South Downs National Park Authority

Principal Areas of Disagreement Summary Statement - Final Issue

29 July 2024

Table 1 – Outstanding Principal Areas of Disagreement

Contains OS data © Crown Copyright and database right 2020 0100031673

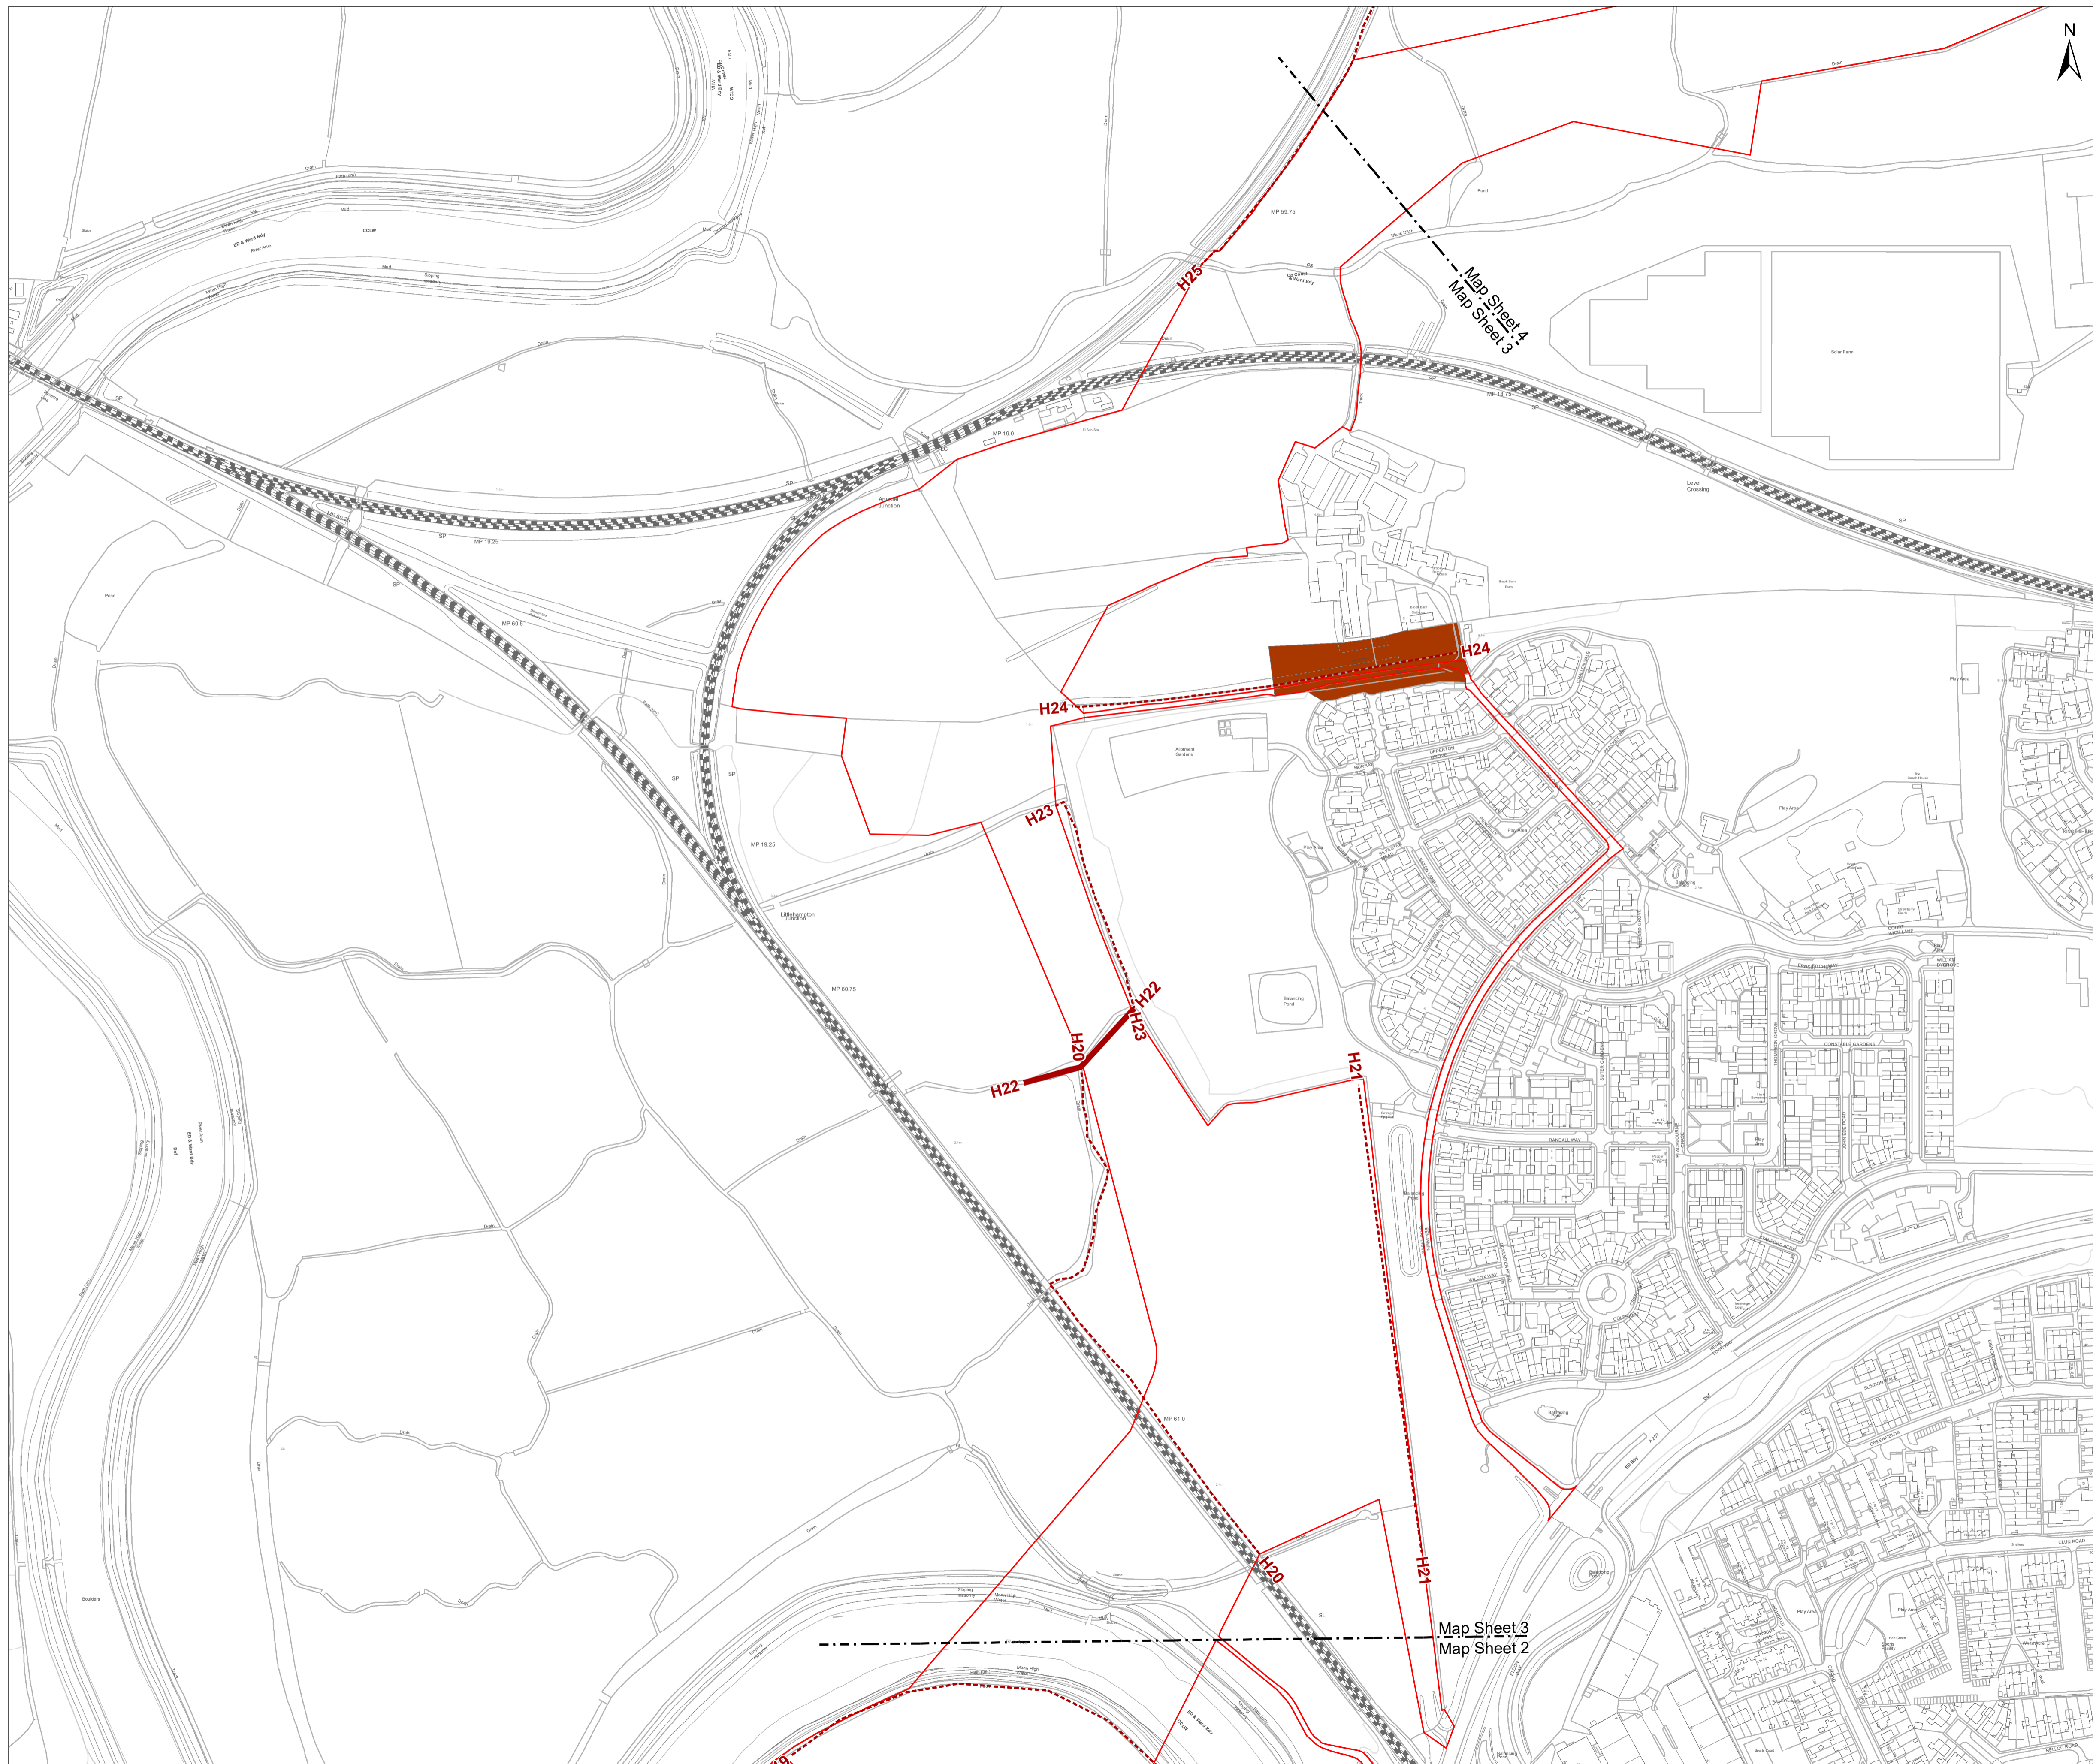
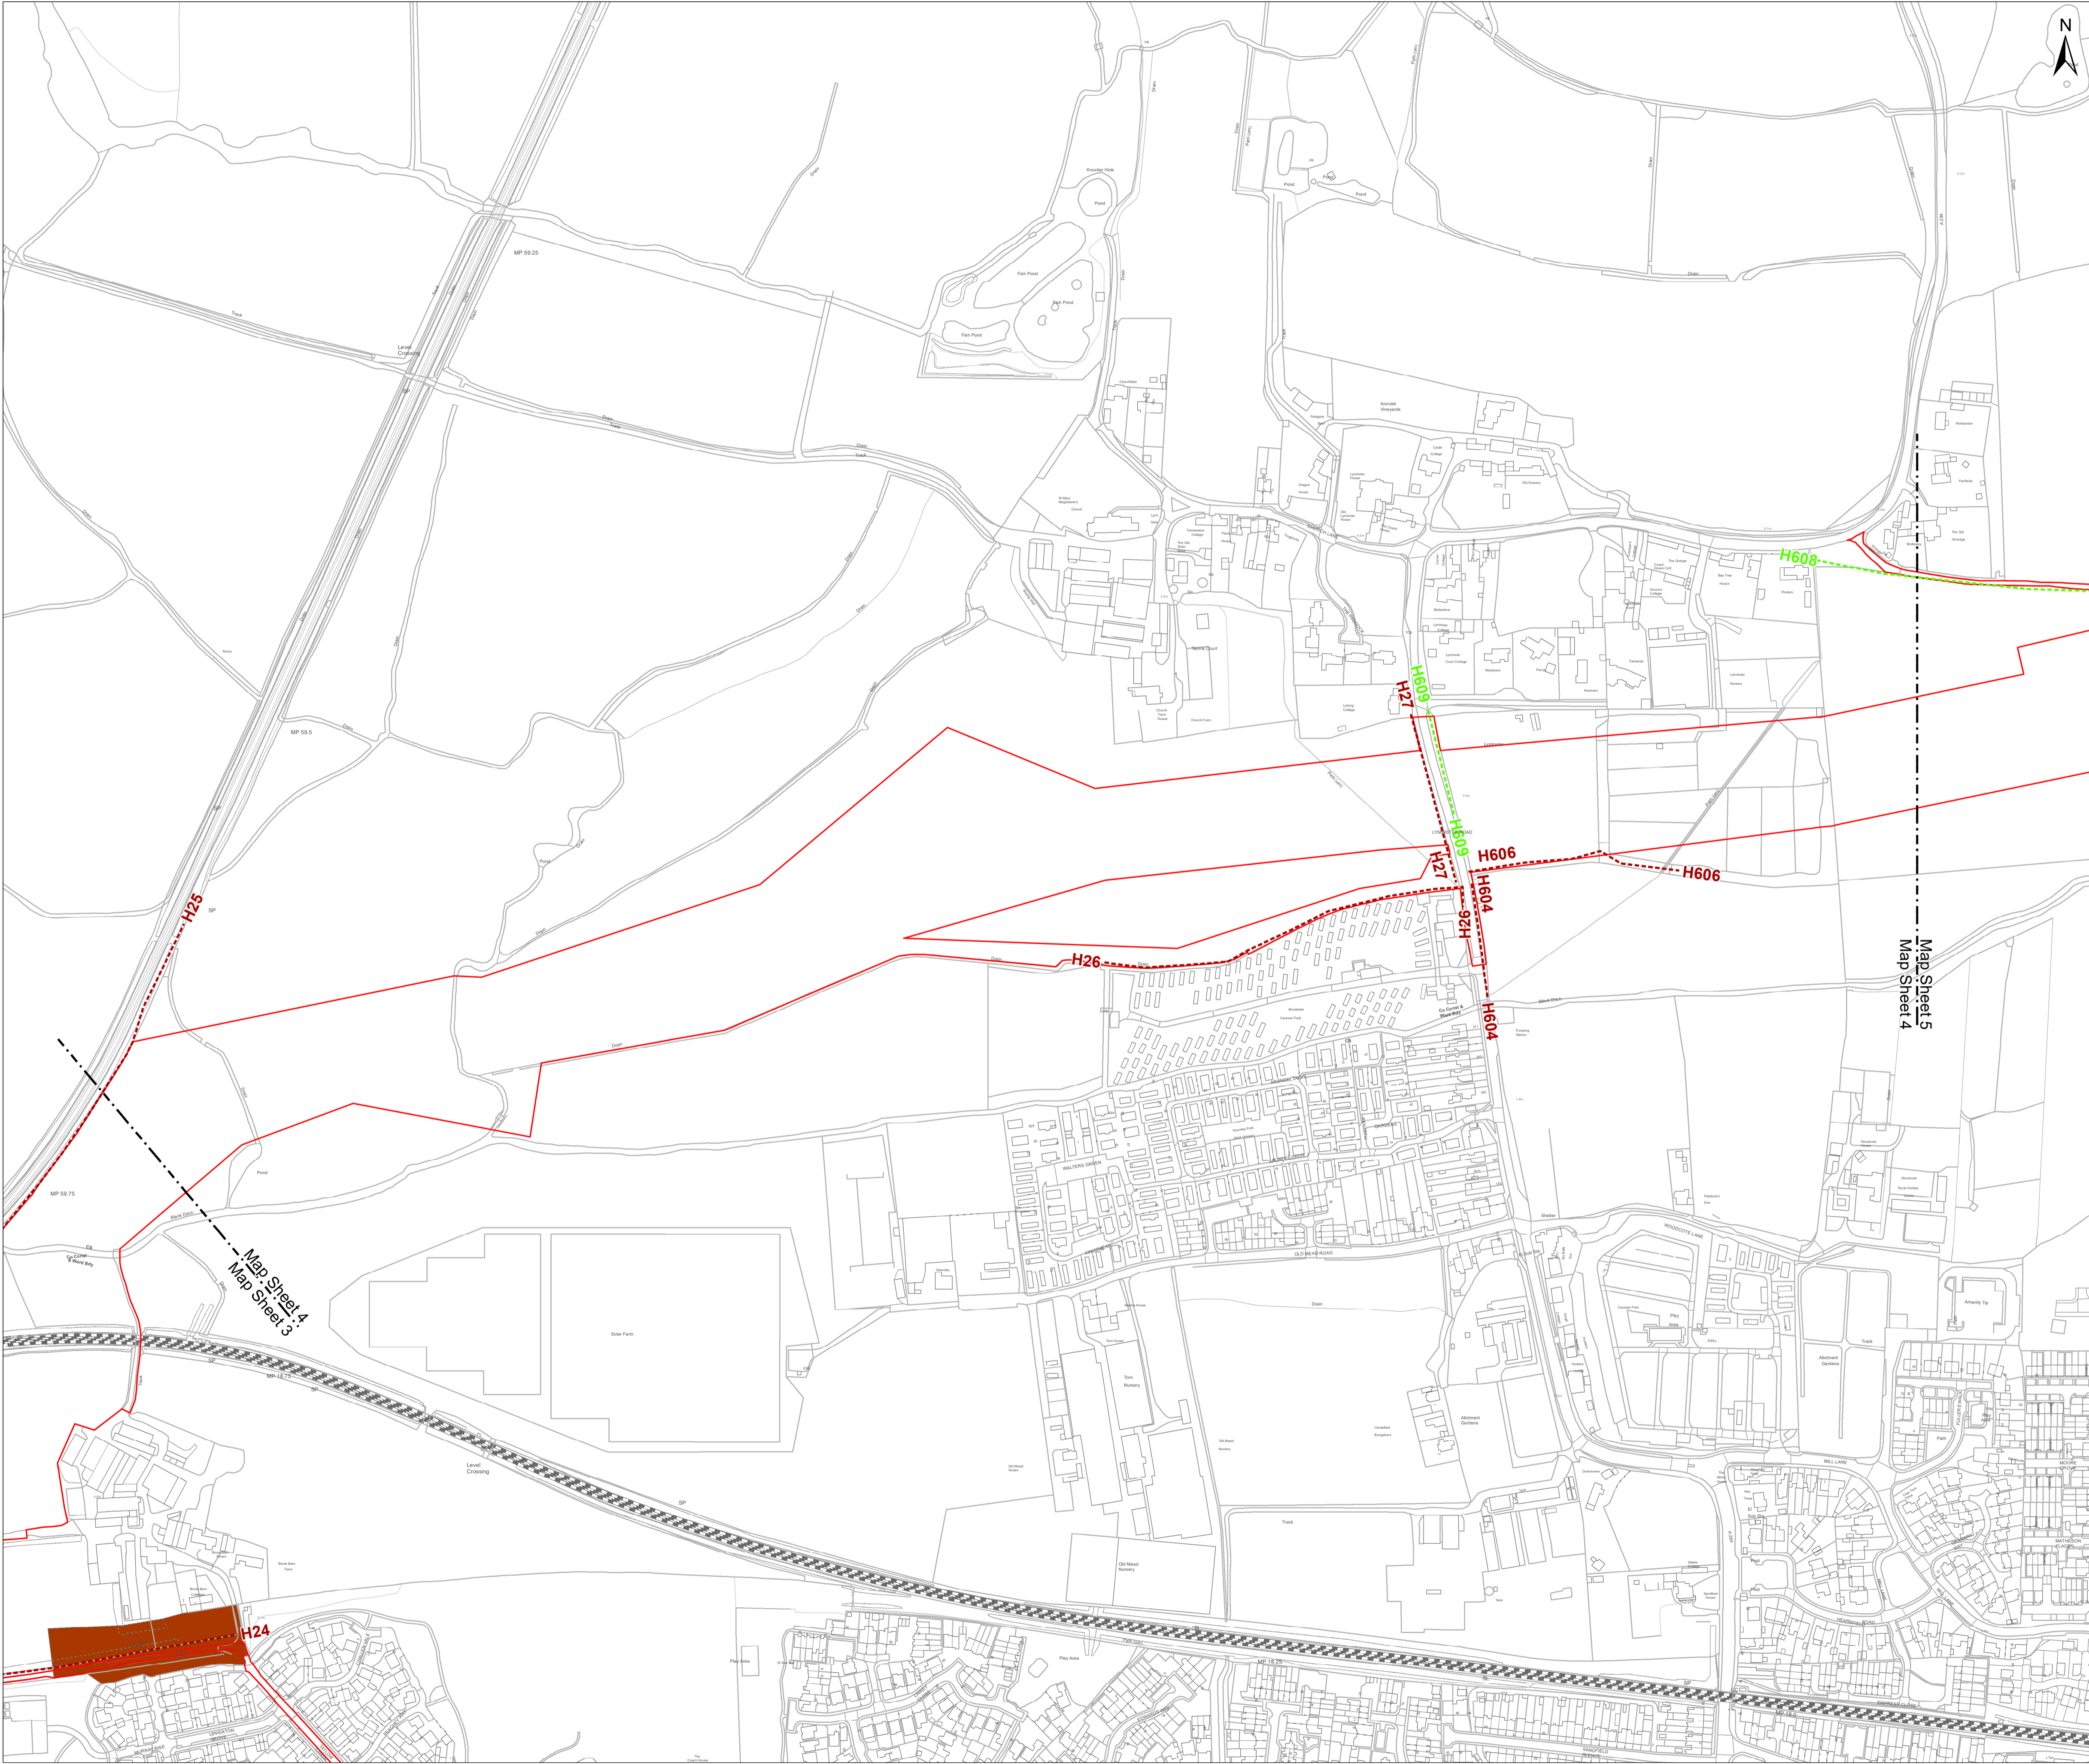
SDA-15	Loss of key Landscape Features	<p>Significant concerns over likely success of proposed hedge notching. The examples cited for use of the technique in the Lake District and Norfolk Broads are not likely to have encountered the challenges of dry, free draining chalk soils. No proven testing undertaken to evidence proposals. If this would not work, the landscape, ecological and visual impact would be significant.</p> <p>Clarity required to explain why 6m width notching technique cannot be used for all hedges regardless of importance.</p>	<p>Applicant to provide further evidence on achievability on shallow chalk soils in Southern England.</p> <p>Applicant to provide further evidence on reasoning.</p>	<p>SDNPA are still not satisfied the proposed hedge notching will be successful in these landscape conditions. Further to this, it will not be possible to reinstate tree belts or mature trees in hedgerow, which are intrinsic features of this landscape. The effects are therefore far greater than the applicant has concluded.</p>
